Recommendation Report for Planning Permission for Works or Extension to a Dwelling**REF NO:** FG/42/17/HH**LOCATION:** 162 Littlehampton Road
Ferring**PROPOSAL:** Garage to front elevation with bedroom above (resubmission following FG/183/16/HH).**SITE AND SURROUNDINGS**

PROPOSED
GROUND FLOOR
LAYOUT PLAN
scale 1:100

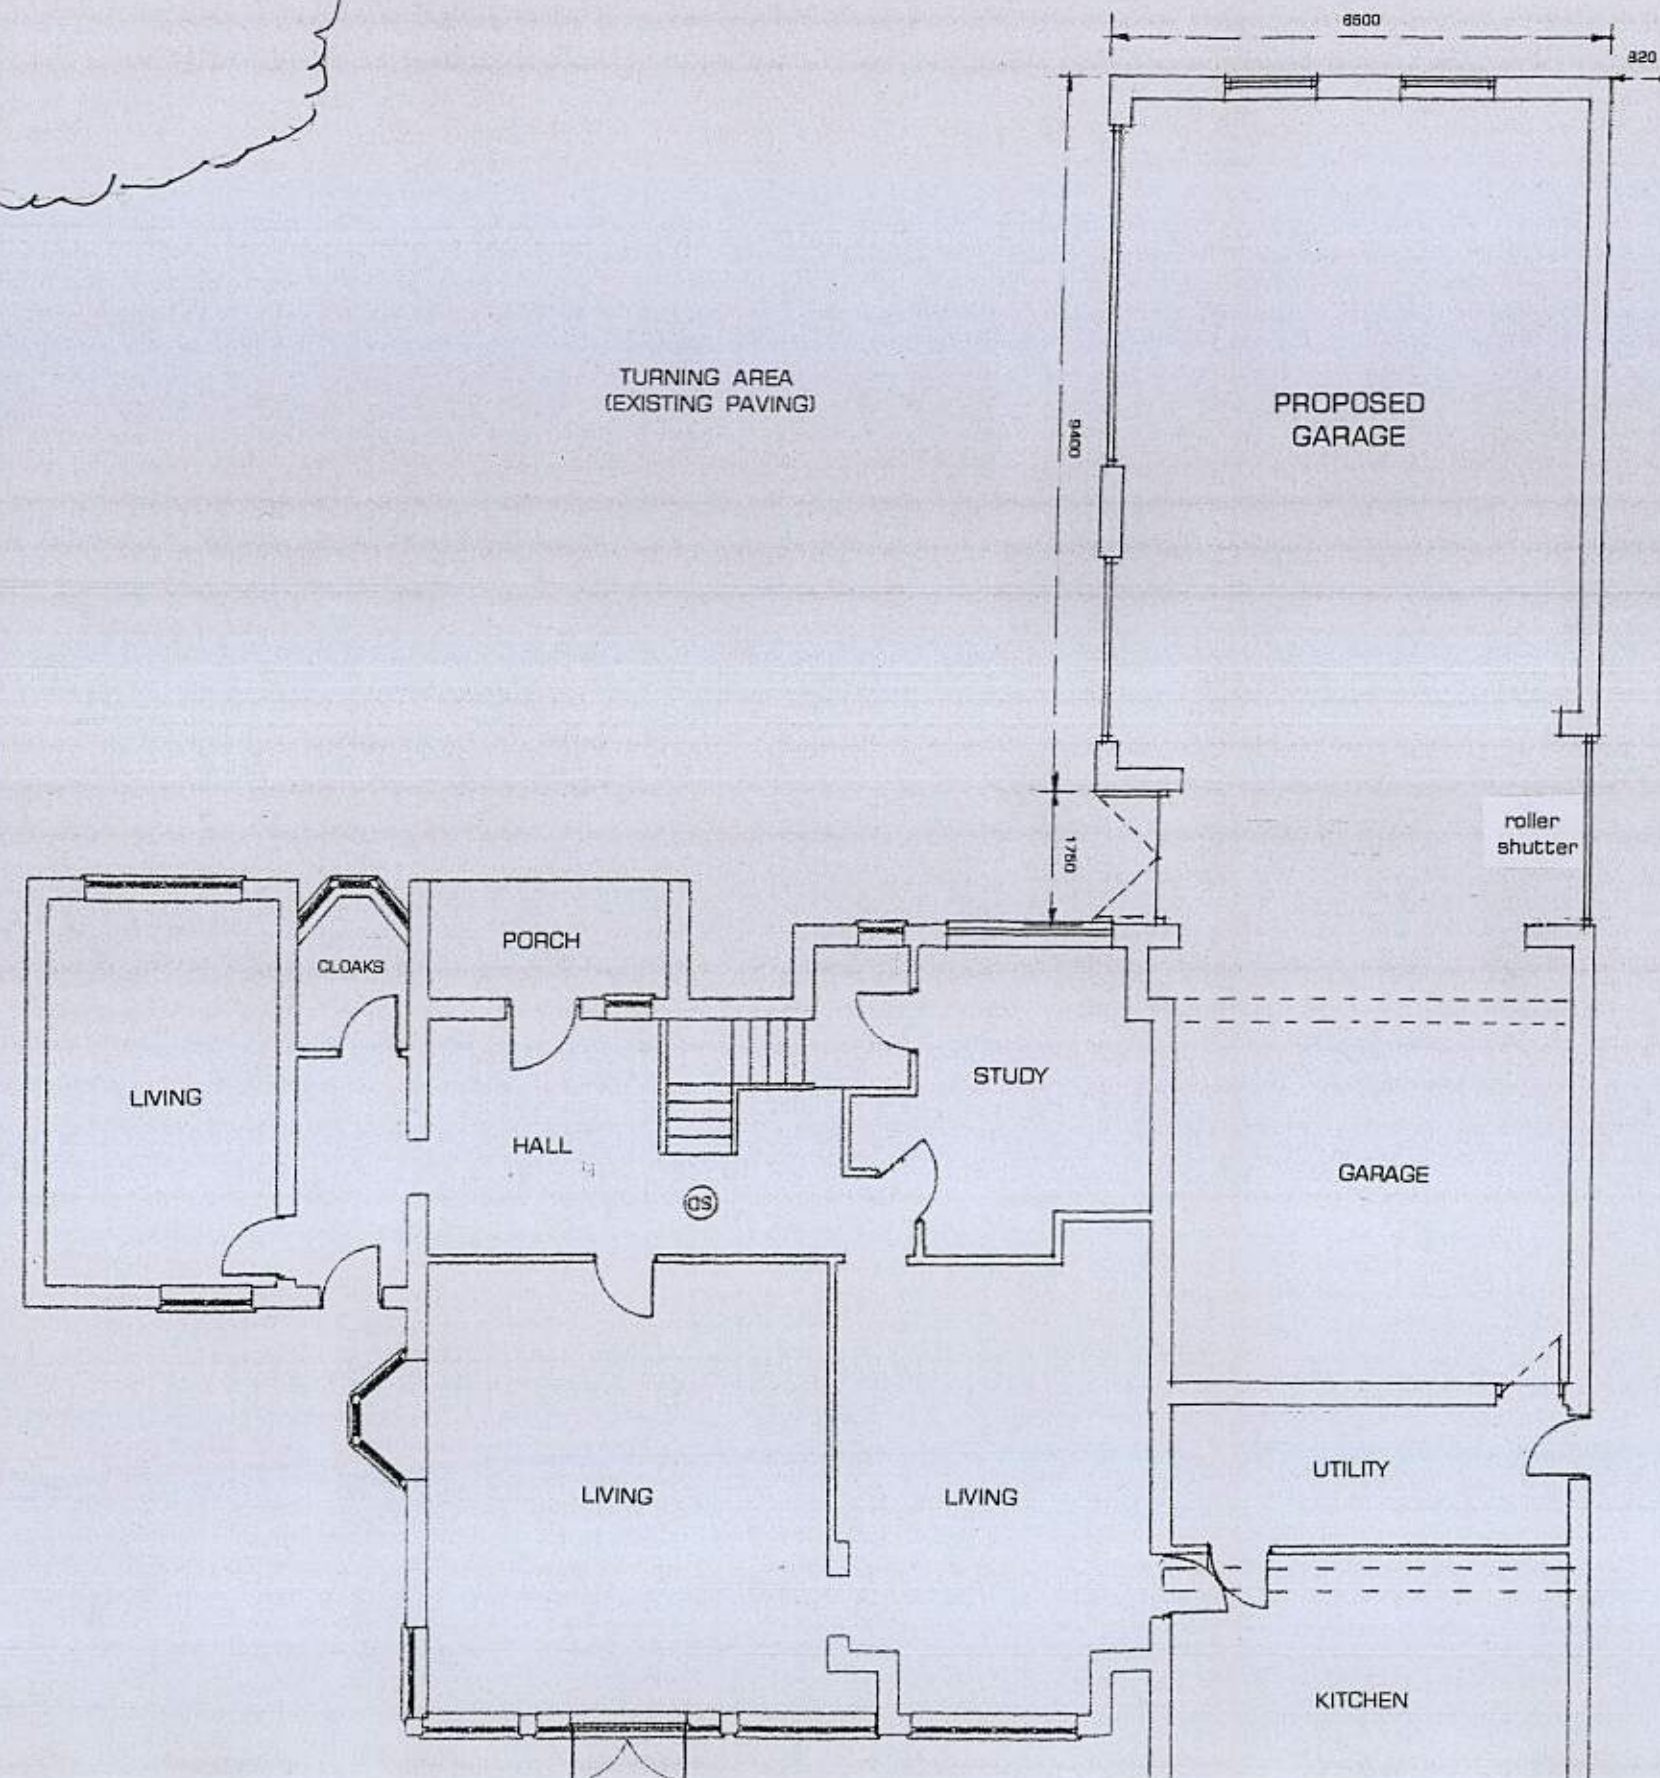
The application seeks planning permission for the construction of a 2 storey extension double garage with bedroom over forward of the front elevation of the dwelling within the front garden area, constructed of materials to match the existing dwelling with metal and upvc doors.

Although the proposed extension would be attached to the property and constructed forward of the existing dwelling there are other single storey garage structures similarly located to the east of the dwelling serving dwellings fronting Ancren Close and there is a high brick wall along the site frontage which screens the front garden area from public view. The lower garage portion of the extension was the subject of application FG/183/16/HH and would be well screened and not readily visible in the street scene and was considered to be acceptable in terms of its impact on visual amenity. However this proposal has increased the height and bulk of the roof and added a first floor which includes 3 dormer windows. This element would be readily visible from outside the site and would result in development at first floor level forward of the front elevation which would visually sit at odds with the other properties fronting Littlehampton Road, which have not been similarly extended, and would compromise the established spatial character and pattern of development in the street. It would be visually prominent and obtrusive in the street scene. Policy DEV19 (I) and (ii) of the Arun District Local Plan also requires extensions to be subservient and visually integrated with the host property. This proposal is considered to conflict with this requirement in that the design and form of the extension would compete with the existing dwelling. The dormers would be significant and would increase the visual prominence of the extension and detract from the balanced appearance of the existing dwelling in conflict with Policies GEN7(ii) of the Arun District Local Plan.

PROPOSED SIDE (EAST) ELEVATION

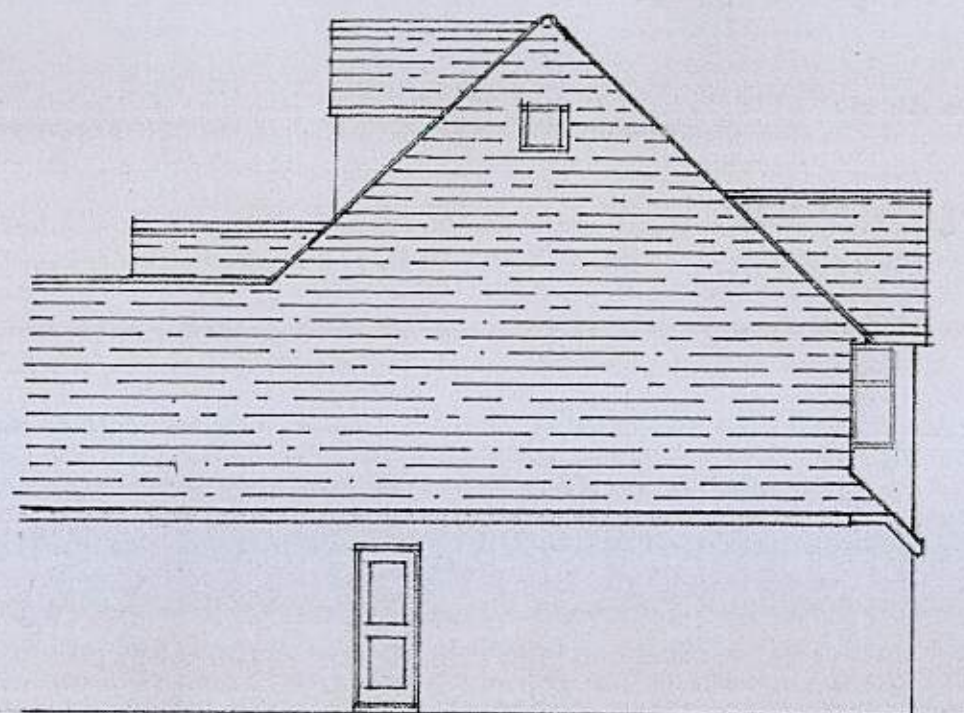
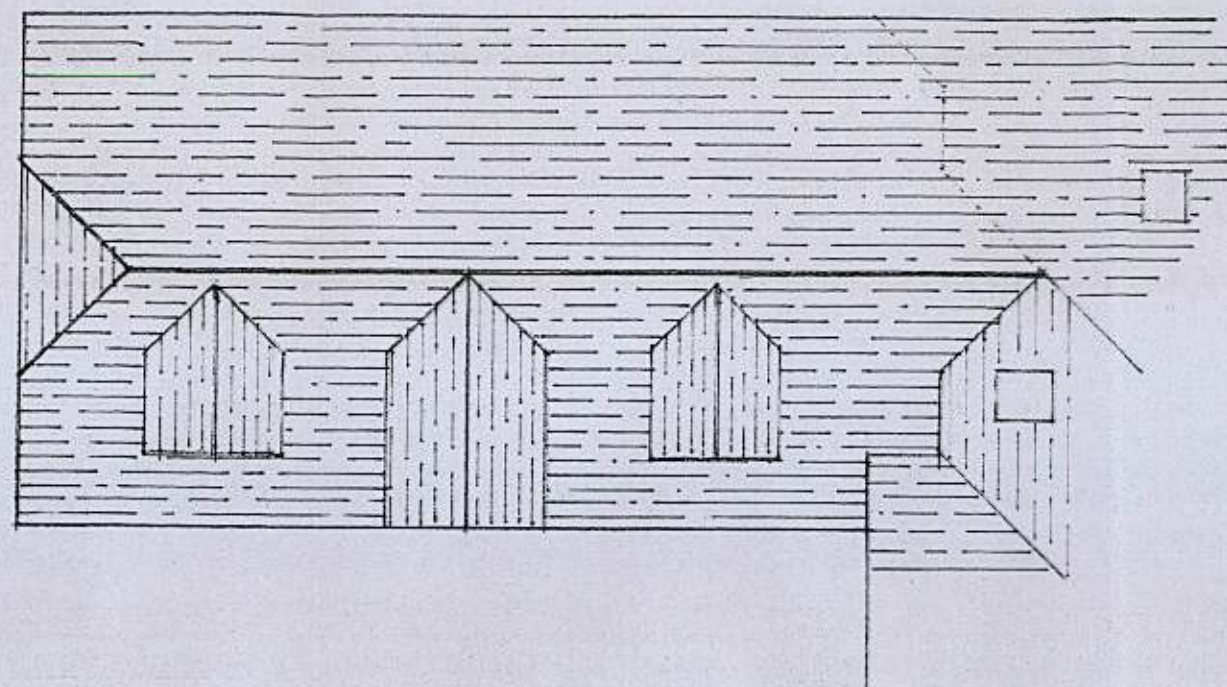
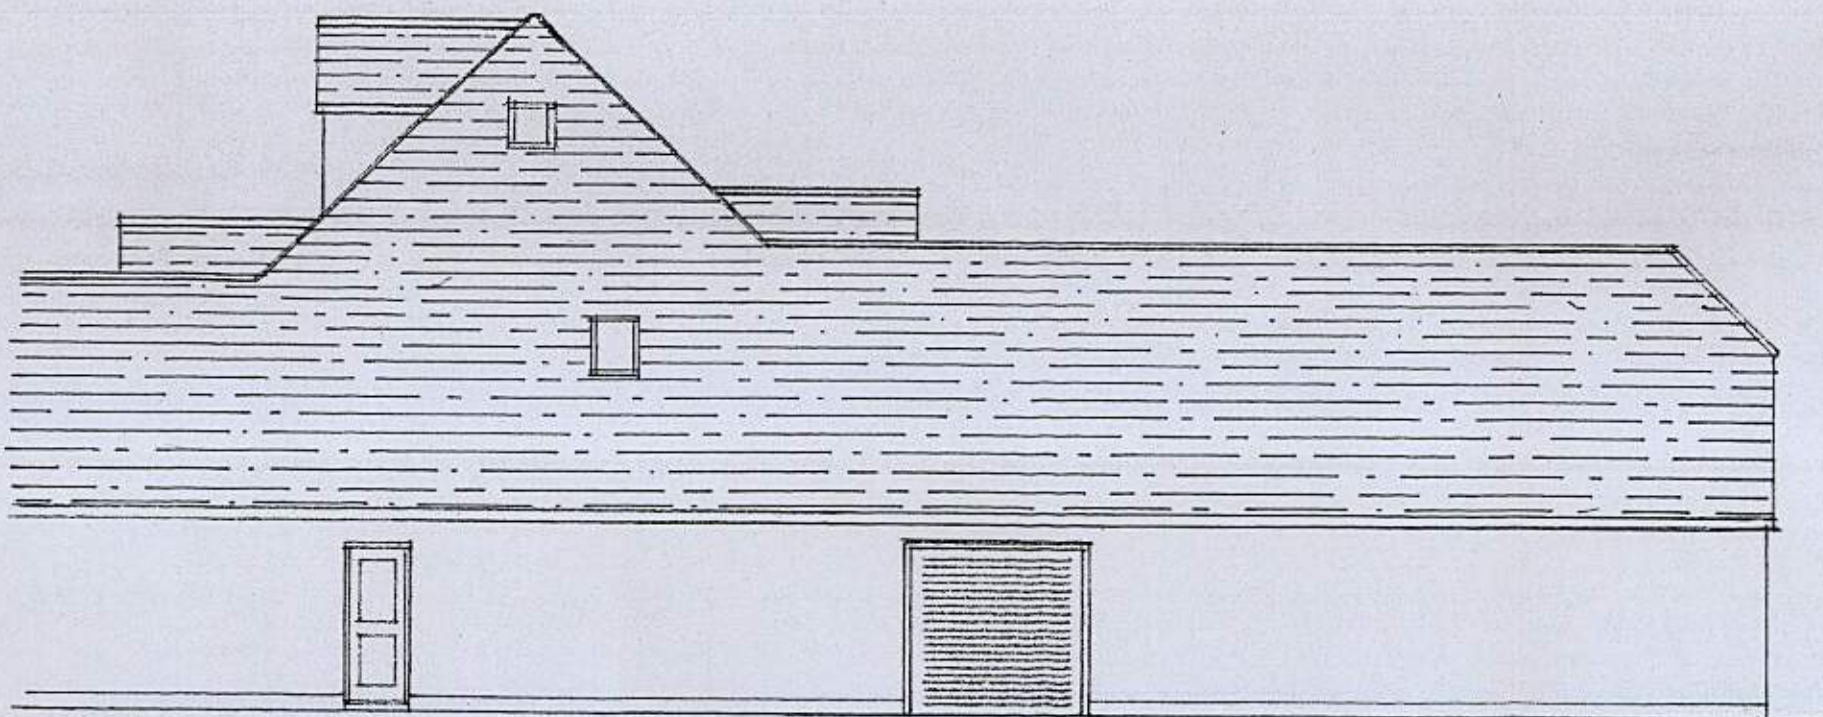
DESCRIPTION OF APPLICATION	As above. The proposal relates to a hipped roof double garage with bedroom above measuring 12.2m by 6.8m in area with a ridge height of 6.2m and an eaves height of 2.4m.
SITE AREA	N/A
RESIDENTIAL DEVELOPMENT DENSITY (NET)	N/A
TOPOGRAPHY	Predominantly flat
TREES	None of any significance affected by the proposed development.
BOUNDARY TREATMENT	Walling to approx. 2m encloses front garden
SITE CHARACTERISTICS	A single storey detached 2 storey dwelling with pitched roof and integral double garage to side not projecting forward of the dwelling.
CHARACTER OF LOCALITY	Predominantly residential characterised by detached dwellings of varying design in large plots set back a similar distance from the site frontage with the A259.

At its closest point the extension would be located 0.82m from the eastern boundary and the roof would pitch away from the shared boundary with an eaves height of 2.4m. The adjacent structures to the east are garages and any overbearing impacts would not therefore cause material harm to the residential amenities of the neighbouring properties in Ancren Close.

- 1 By reason of the height, design and size of the extension it would result in a prominent and obtrusive form of development which would appear out of keeping in the street scene and would not be subservient to the existing dwelling adversely affecting the visual amenities and character of the area in conflict with policies DEV19 and GEN7 of Arun District Local Plan.
